Application no: **3/2023/0142**

Address: **The Hawthorns West Bradford Road Waddington BB7 3JE**

Proposal: **Demolition of existing dwelling. Creation of two new semi detached dwellings with associated access, parking and garden areas.**

The Local Highway Authority have viewed the plans and highway related documents and have the following comments to make:

A1.5

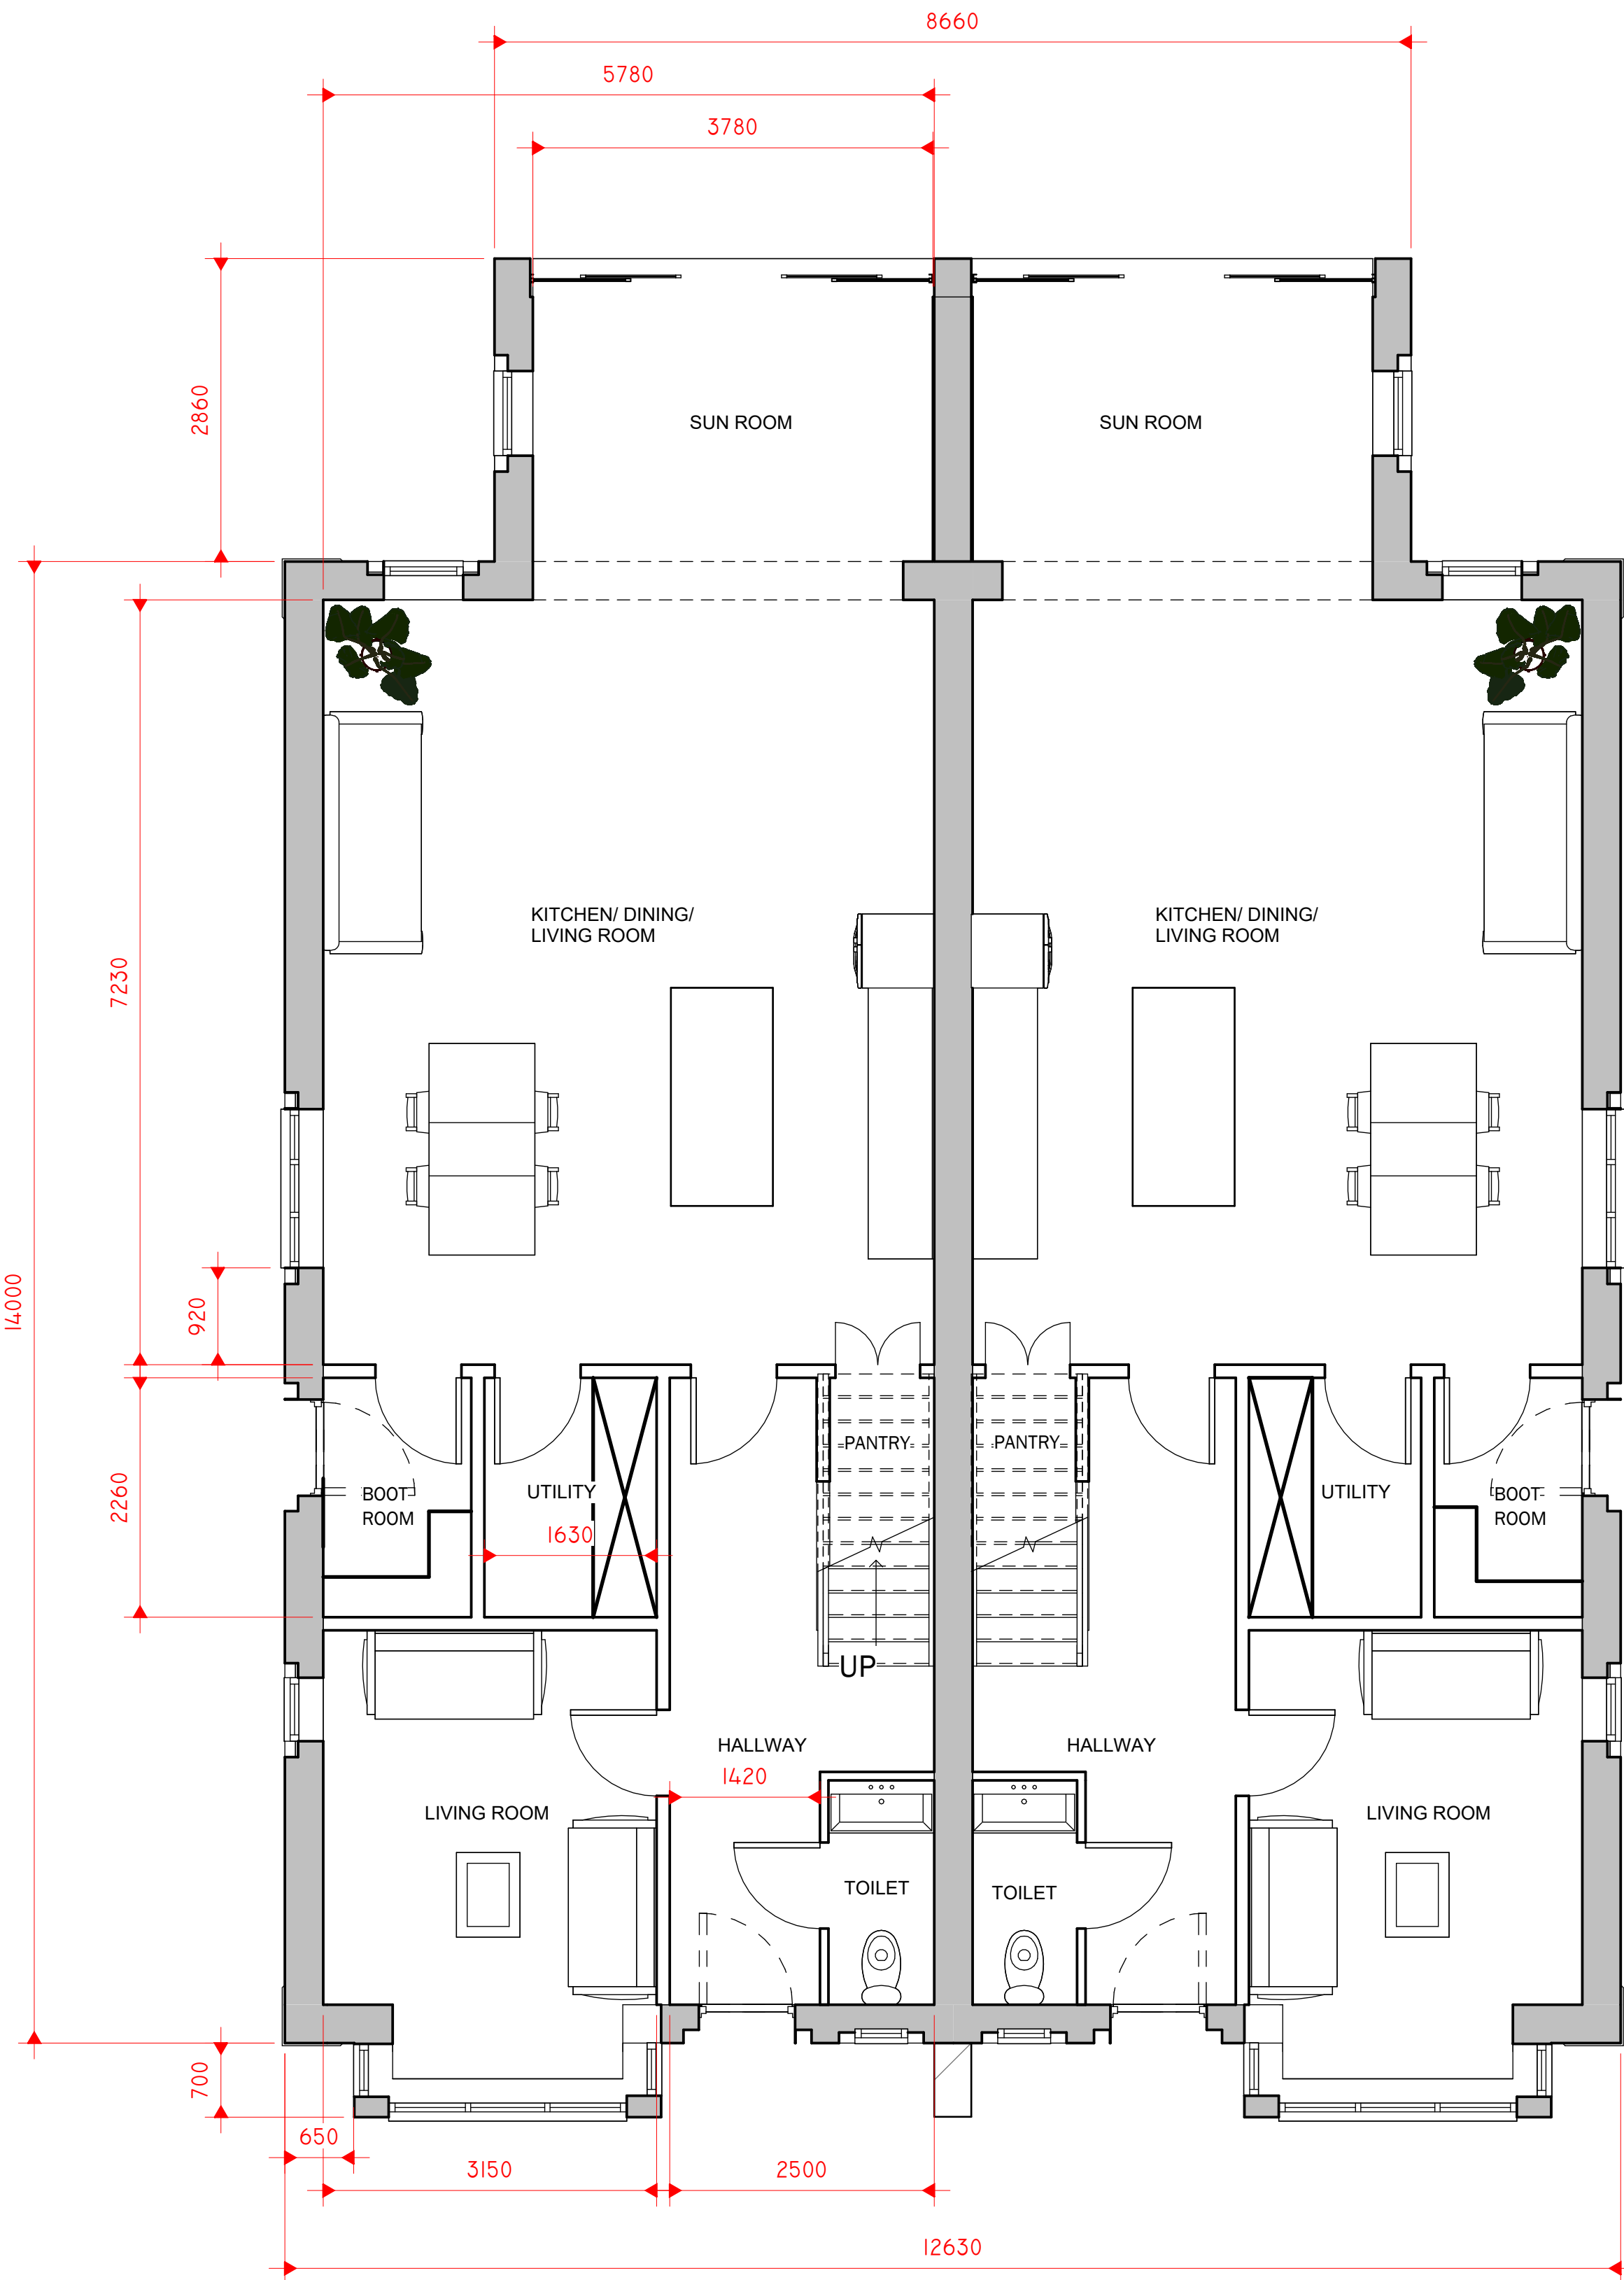
The LHA have reviewed Peter Hitchen drawing number A1.5 titled " Proposed Site Plan 1 Revision 1" and are aware that the existing access will be recentred to serve both dwellings. The LHA have reviewed the proposed access and are aware that the access width complies with the LHAs guidance when serving two dwellings.

The LHA are also aware that access can provide visibility splays of 2.4m x 43m in both directions, which complies with the LHAs guidance.

The LHA have reviewed Peter Hitchen drawing number A1.5 titled "Proposed Site Plan Revision 1" and are aware that 2 car parking spaces can still only be provided for each 4-bed dwelling. This does not comply with the LHAs parking guidance as defined in the Joint Lancashire Structure Plan with the LHA requiring 3 car spaces to be provided for each dwelling.

As a result, the LHA still require a revised site plan to be submitted showing that 3 car parking spaces can be provided for each dwelling. This can be achieved by relocating the footprint of the proposed dwellings a further 2.4m from the adopted highway to provide the additional space.

Unfortunately, due to the site not being in a sustainable location, with there being no bus stops located within 400m of the site and the LHA not wanting the site to provide the shortfall of parking on-street due to this restricting the operation of West Bradford Road, to only allowing one-way movements to occur simultaneously, the LHA are requesting that the full quota of parking is adhered to.

The LHA have further reviewed Peter Hitchen drawing number A1.5 titled "Proposed Site Plan Revision 1" and welcome the widening of Public Footpath FP0343023. The LHA do still advise the Agent that a diversion order may still be required given that the Public Footpath is not located on its definitive line.
